Appendix A Record and Response to Submissions

Extracts from Government agency and authority submissions received in relation to SSD 18_9326, and a response to each of these matters, has been outlined in the table below. It is noted that no submissions were received from the general public.

Figure 2: Test locations and Lawson comfort ratings – South Site terraces

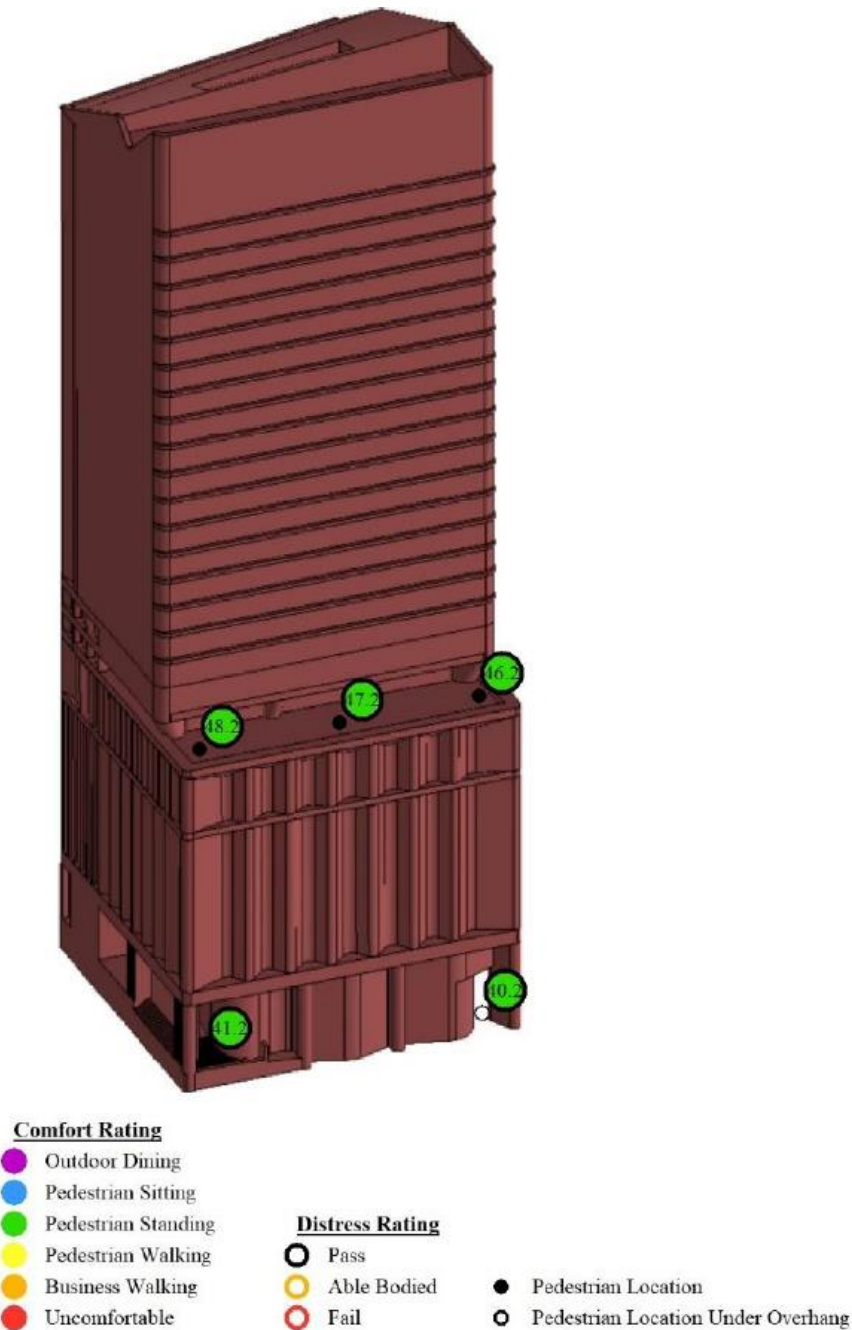
<p>6. Additional information</p> <p><i>I. Provide options to improve wind conditions where areas are designed for outdoor seating or outdoor uses, including assessment of visual impacts of any recommended structures</i></p> <p><i>Note the wind assessment considers the podium terrace of the South Site is appropriate for 'pedestrian standing' only.</i></p>	<p>A wind assessment addendum has been prepared by CPP and is included in Appendix G. The letter considers the appropriateness of wind conditions on the proposed terrace.</p> <p>Overall, CPP advise that the measured conditions for the terrace are similar to or better than comparable terraces in the Sydney CBD. The terrace would experience winds less than 4m/s for 85% - 90% of the time, meaning that it is only during a small proportion of the time (10% - 15%) where the winds would be stronger than a light breeze.</p> <p>The intended fit-out and use of the terraces will be informed by any specific tenant requirements, and which may include depending on the tenant's brief and requirements, the adoption of specific localised wind mitigation measures.</p>

NORTH ELEVATION
SCALE 1:1000

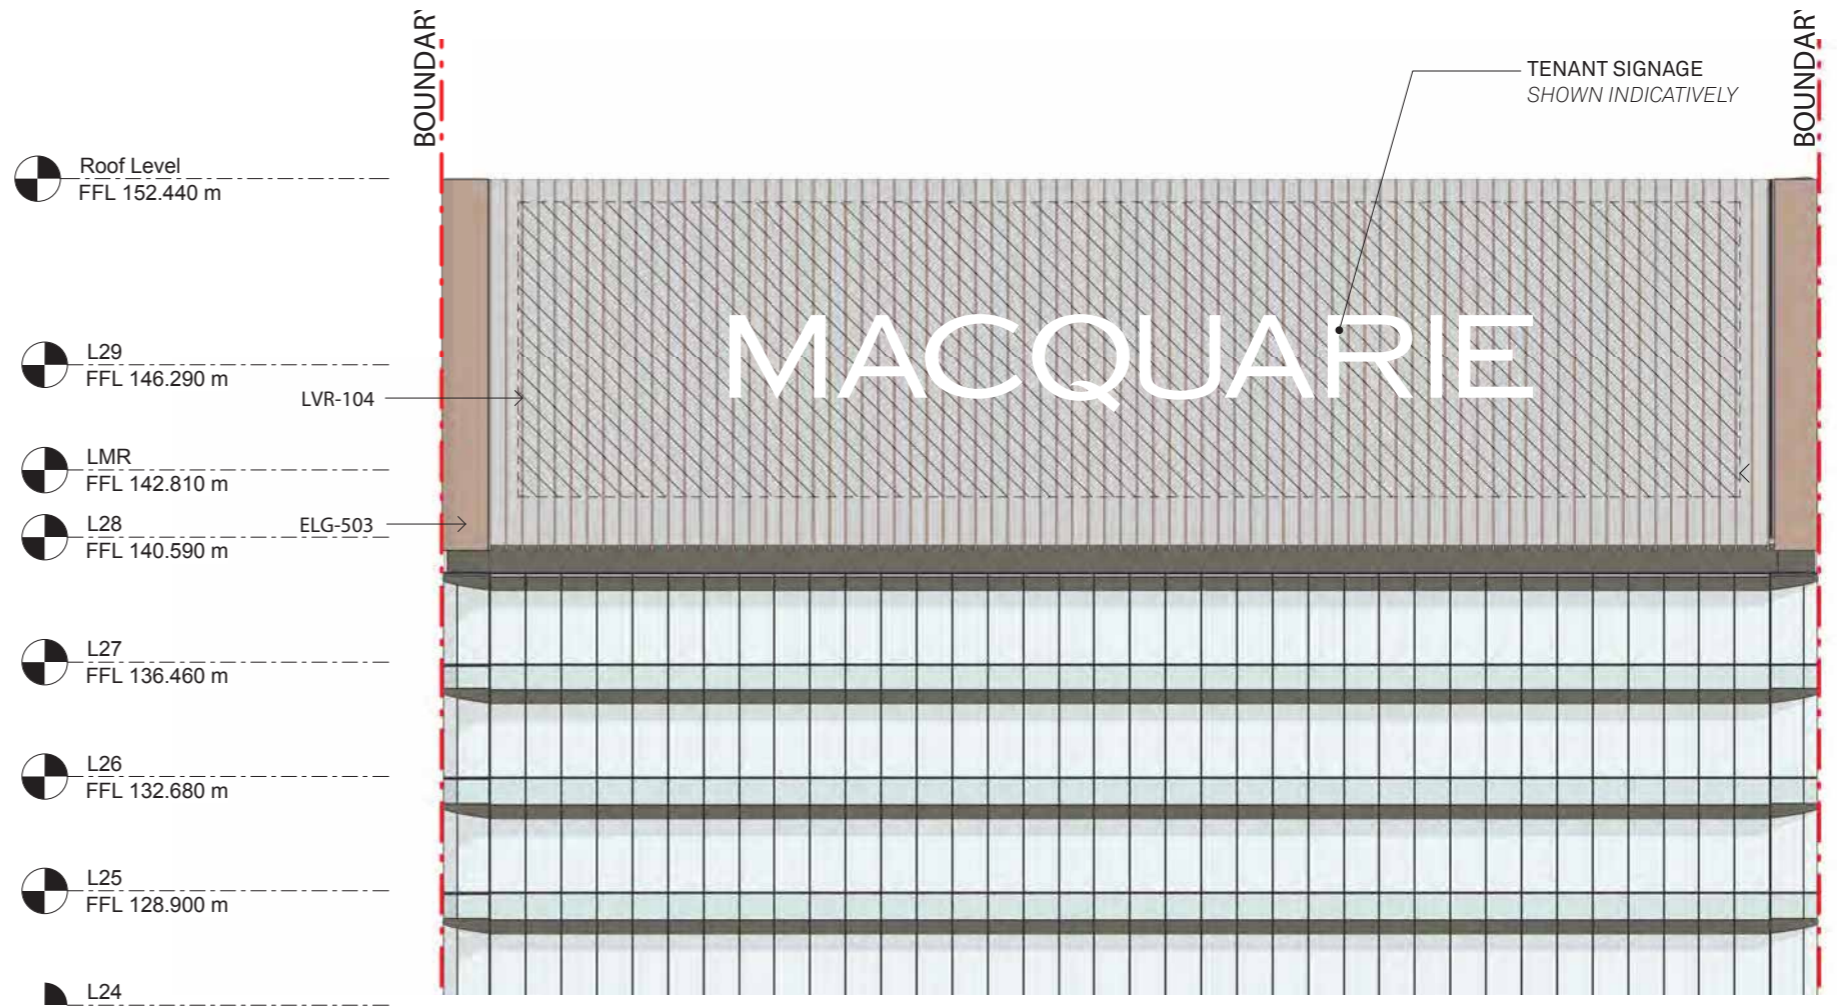
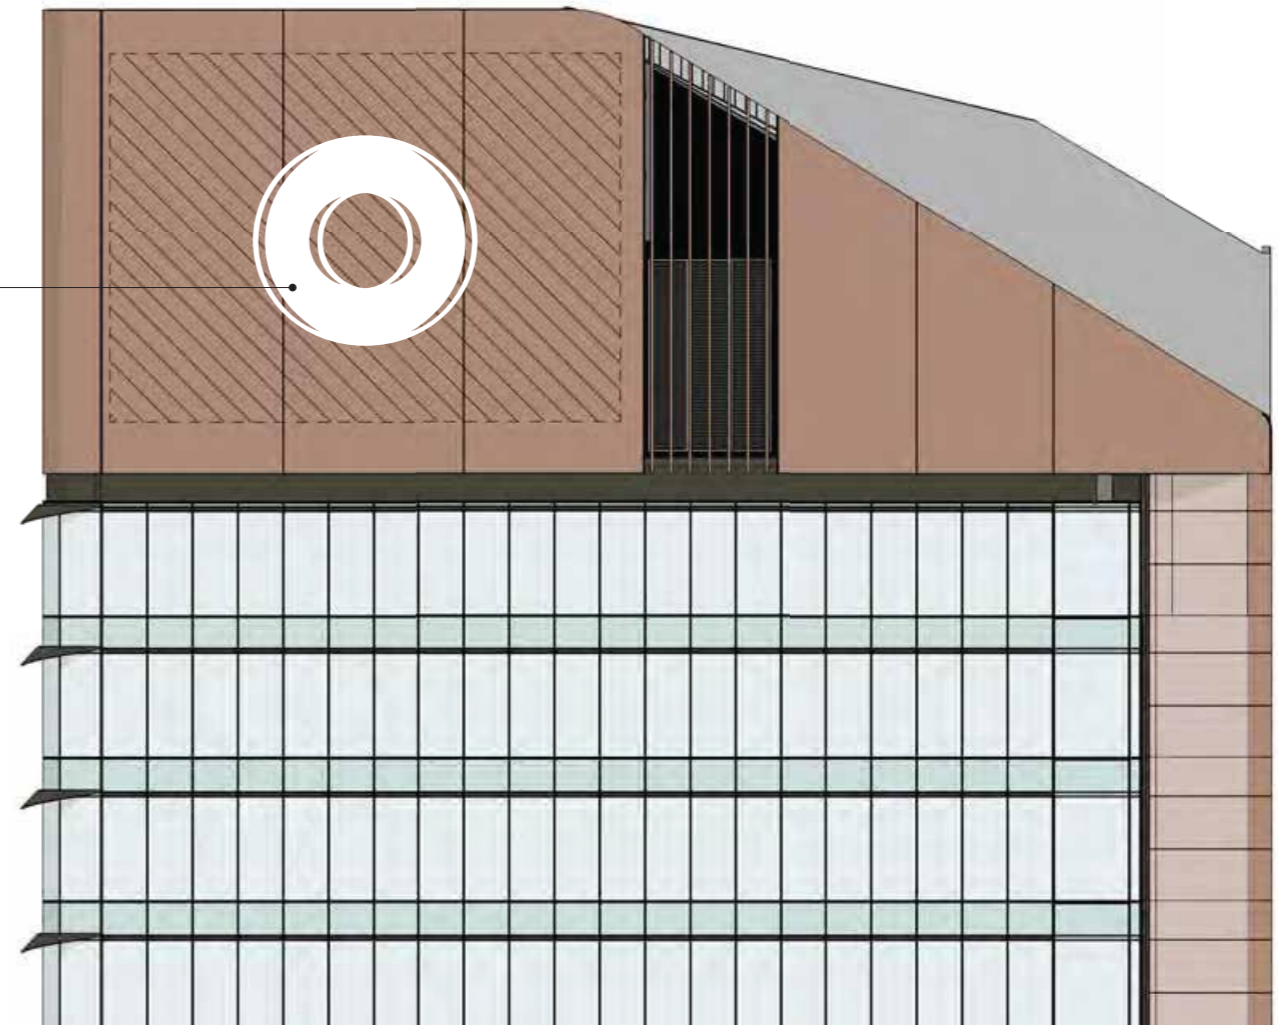
<p>4. Signage</p> <p><i>Consider the appropriateness of the proposed signage zones (and the deferral of detailed design of the signs) with respect to:</i></p> <p><u>South Site</u></p> <p><i>II. The proportion and size of proposed signage zones in response to the unique "crown" roof line/forms of the South Tower.</i></p>	<p>In order to respond to concerns raised by Council about the number of proposed signage zones, the Architectural Plans have been revised (Appendix B) to reduce the extent of signage, by removing one of the top of building signage zones. The revised design addresses Council's comments and provides two top of building signage zones, being a zone on the northern façade and western facade. The proposed signage zones have been designed with consideration of the North Tower's building proportions, roof form and the location of plant.</p> <p>Included in Appendix S is a signage strategy which provides an illustrative scheme of potential future signage within the signage zones. The illustrative scheme demonstrates that signage within these zones can integrate with the curved façade of the building, in prominent locations and where they will not impact on tenant views. The zones are also located to ensure there is no impact to the operation of a future building maintenance unit (BMU). The illustrations at Appendix S demonstrate how an illustrative signage design could integrate with the building within the north facade zone.</p> <p>The designs of the signage zones are considered to be appropriate with reference to the unique 'crown' roof line of the South Tower. The signage zones have been scaled with regard to the proportions and profile of the South Tower roof.</p>
